Sizewell C Non material change application

Personal response from Michael Taylor

18th June 2026

DRAWING TITLE:
**MAIN DEVELOPMENT SITE
 GENERAL ARRANGEMENT
 ILLUSTRATIVE - FOR INFORMATION**

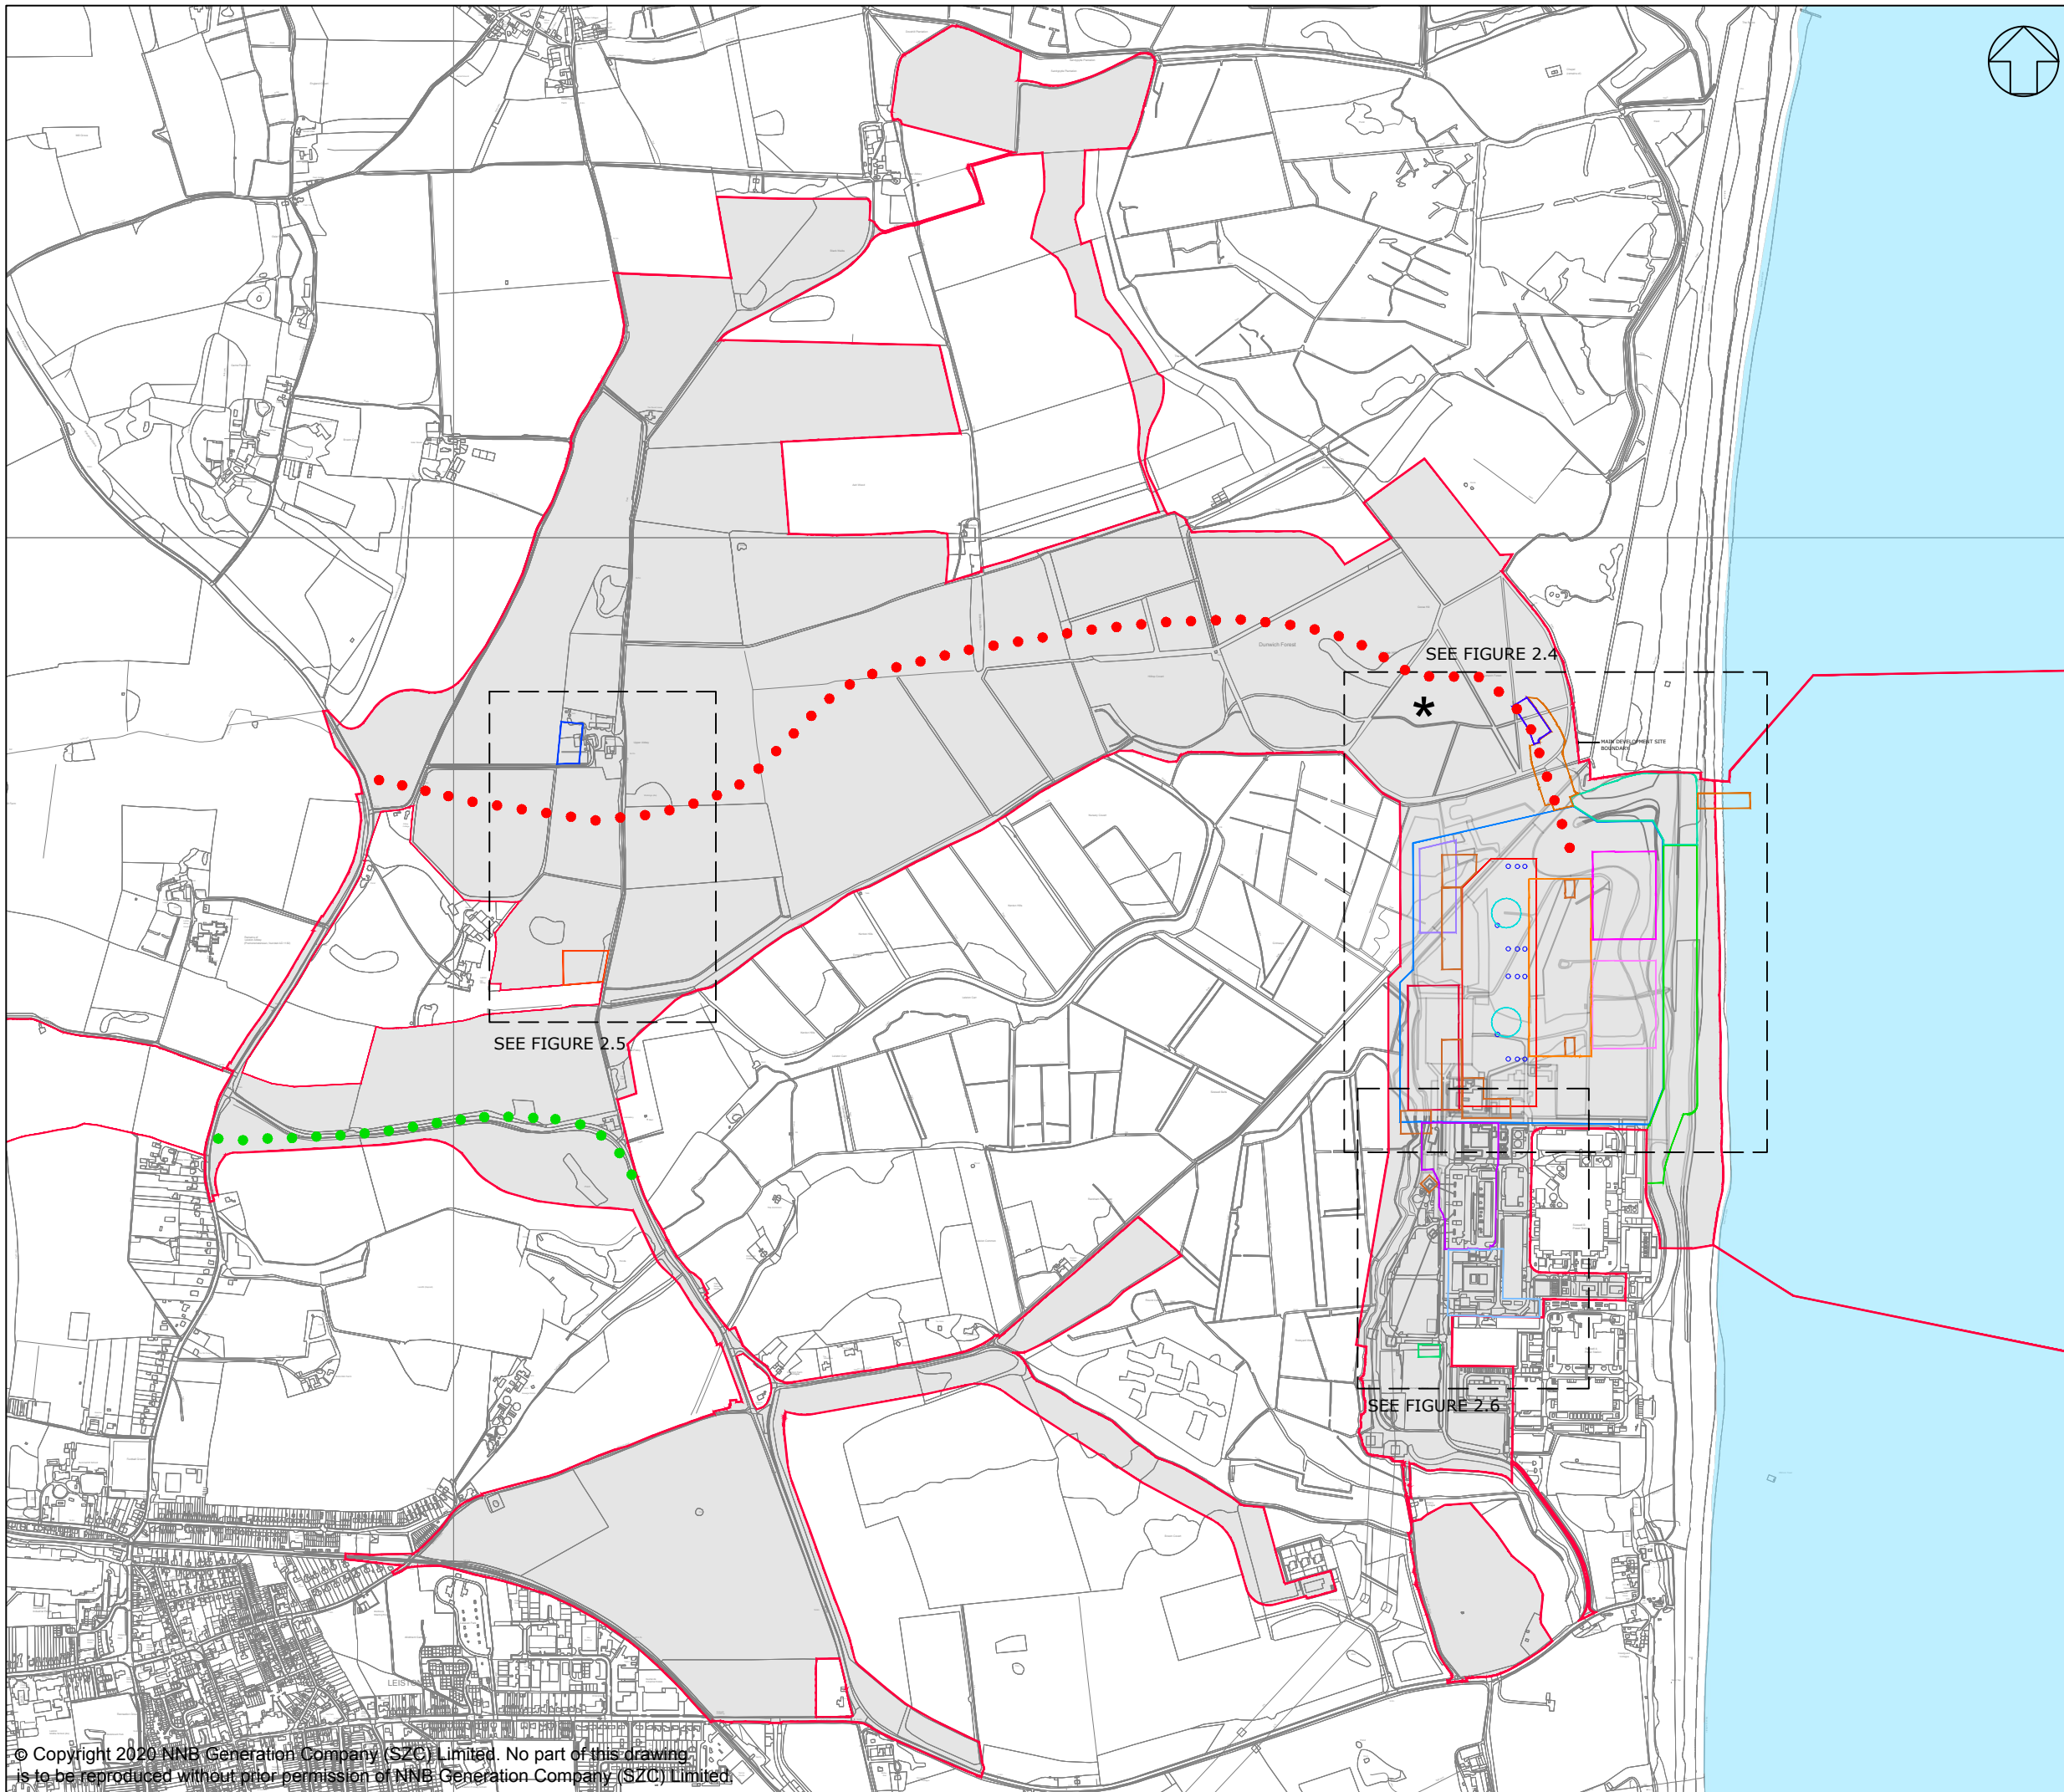
- Where are the proper Main site plans in this application for Non Material Changes ? An example of the site plan was shown in [EN010012-001801-SZC Bk6 ES V2 Ch2 Description of Permanent Development Fig2.1 2.13.pdf](#)
- But those drawings are marked NOT TO SCALE

DRAWING TITLE:
 CONSTRUCTION PHASE

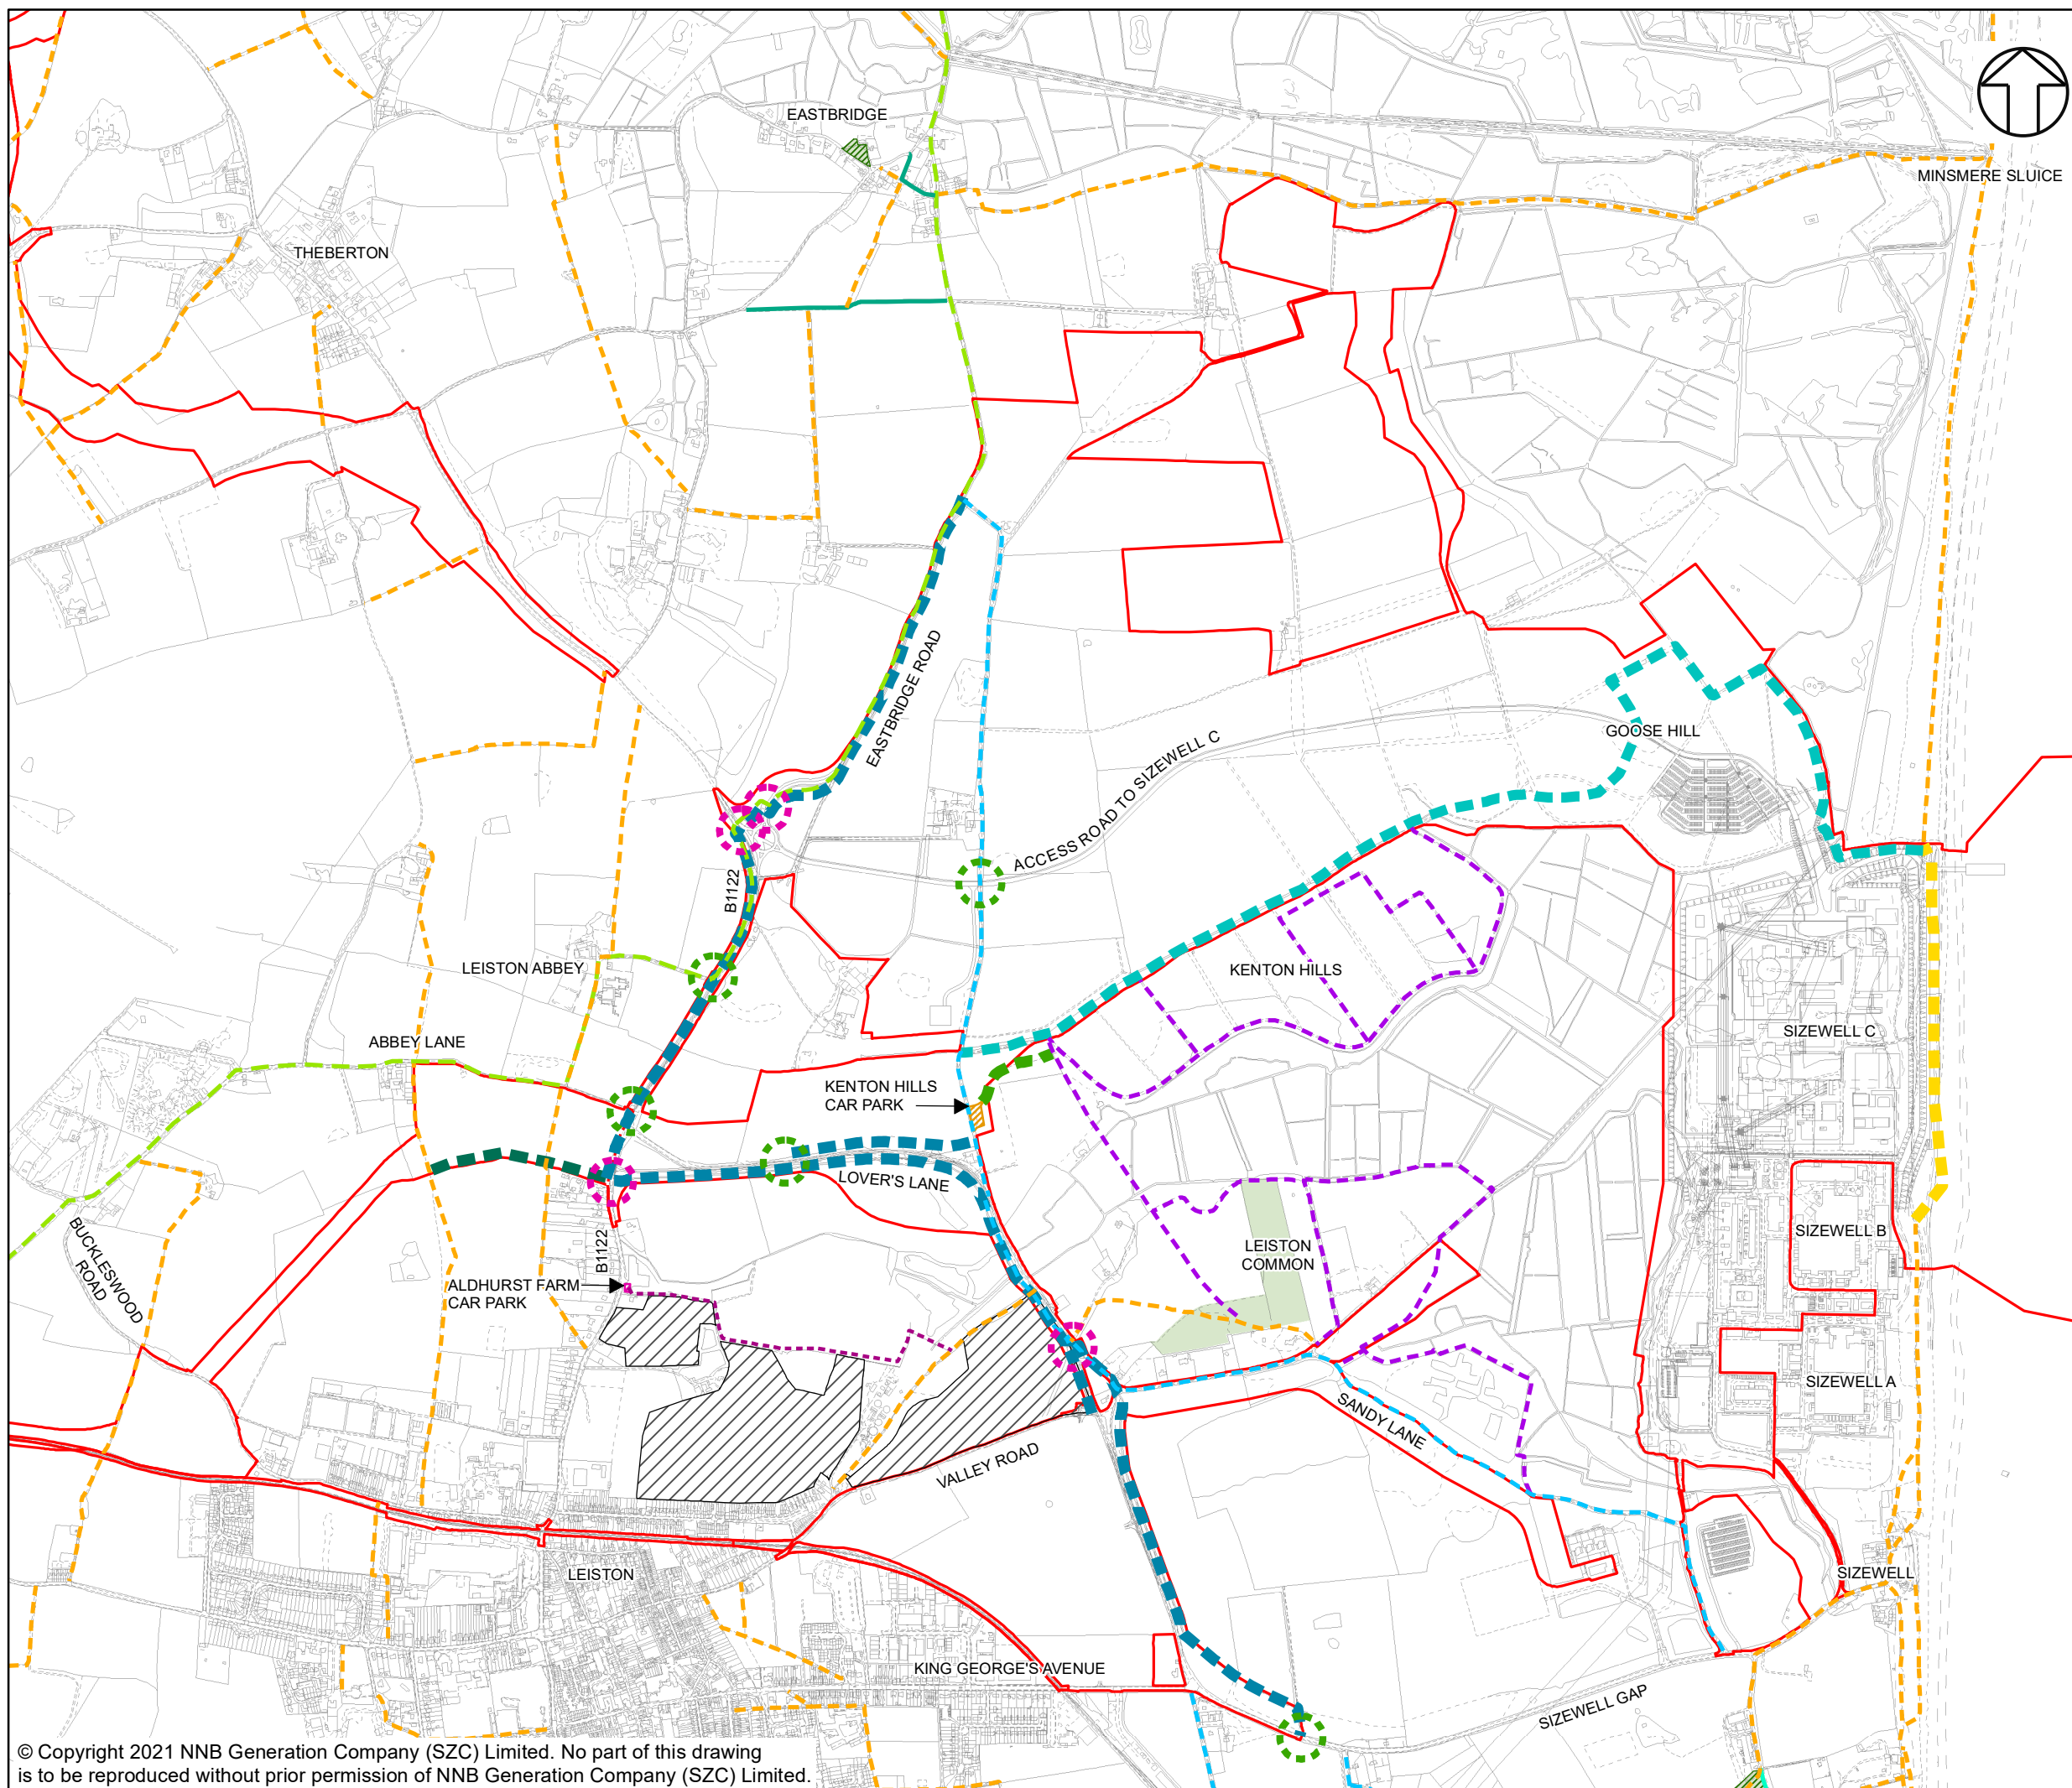
A consultation on RoW essential each parish must be consulted. Reference SCC Definitive ROW

[Definitive Map and Statement of public rights of way - Suffolk County Council](#) Numbers
issue and lack of detail evident .
